Subject: FW: Planning Consultation on: BN/81/20/DOC

Engineers Comments Regarding Surface Water Drainage

Application No: BN/81/20/DOC
Registered: 23rd July 2020
Site Address: Swallowfield Eastergate Lane Eastergate PO20 3SJ
Description of Works: Approval of details reserved by condition imposed under ref BN/121/19/PL relating to Condition Nos 3 - surface water drainage, 4 - Construction Management Plan, 5 - materials & finishes, 6 - hard & soft landscaping, 7 - drainage scheme, 8 - storage of waste and 13 - renewable energy.

Revision:			
address Swallowfield, Eastergate Lane Eastergate, PO20 3SJ			
project Proposed construction of detached chalet bungalow			
title Proposed Surface Drainage			
scale 1:500 @A4	date May 2020	dwg no 2019.257DRA	revision

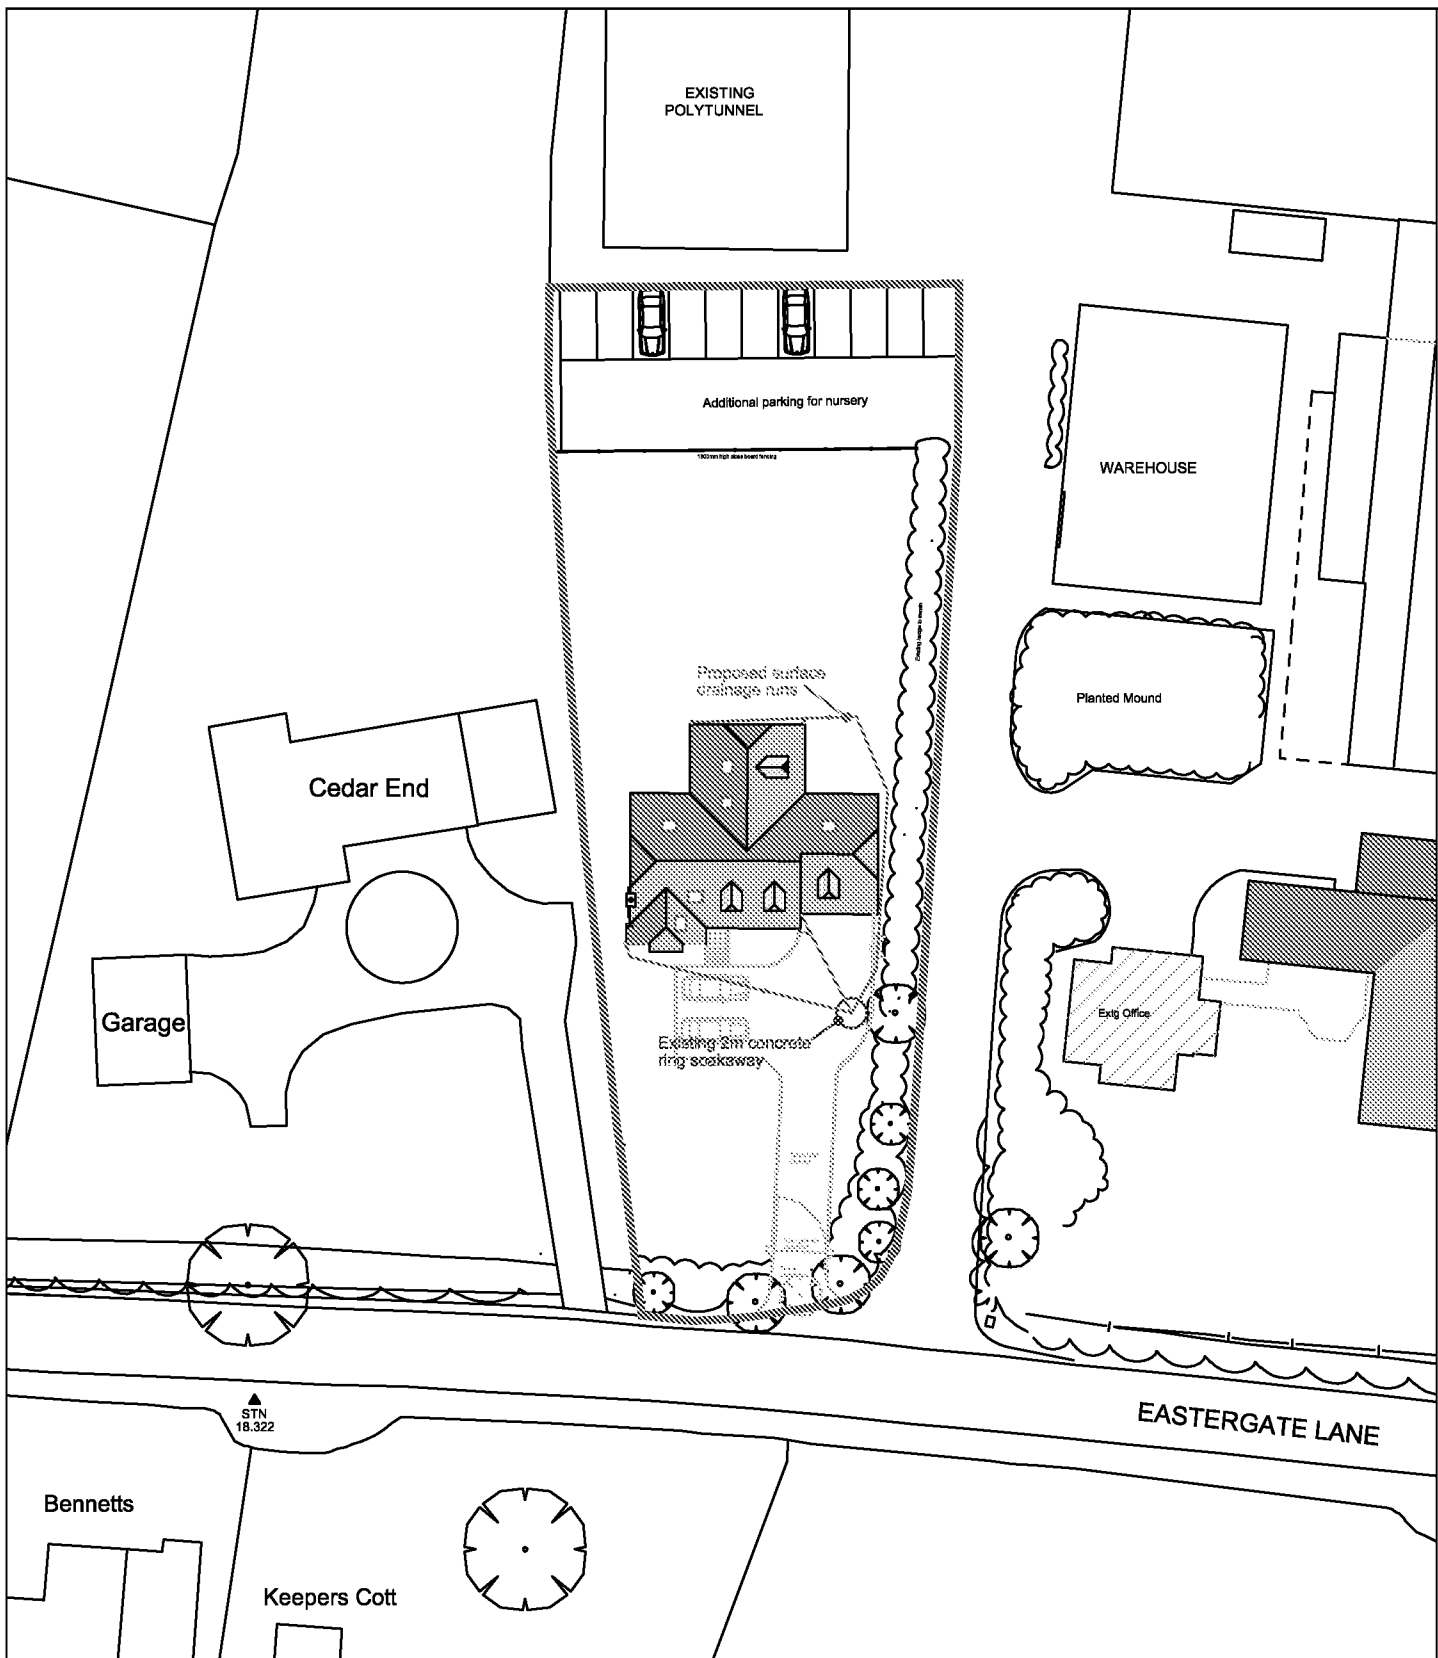
The information supplied is insufficient to recommend discharge of condition 3 and 7 on application BN/121/19/PL. Whilst the principle of utilising the existing soakaway may be feasible, calculations will need to be provided to show that it meets our requirements, and a detailed drainage layout and construction details will also be required. These calculations will rely upon winter infiltration testing (and groundwater monitoring) as per condition 3.

We provide a [Surface Water Drainage Checklist](#) which applicants are guided to in an informative on their decision notice, this makes clear the level of detail required in terms of testing, calculations, the drainage layout and the construction detail drawings. Given that we are currently months away from the winter period, unless the applicant is able to provide winter results from a previous year, I would recommend that the application is refused and a new submission is made in early 2021.
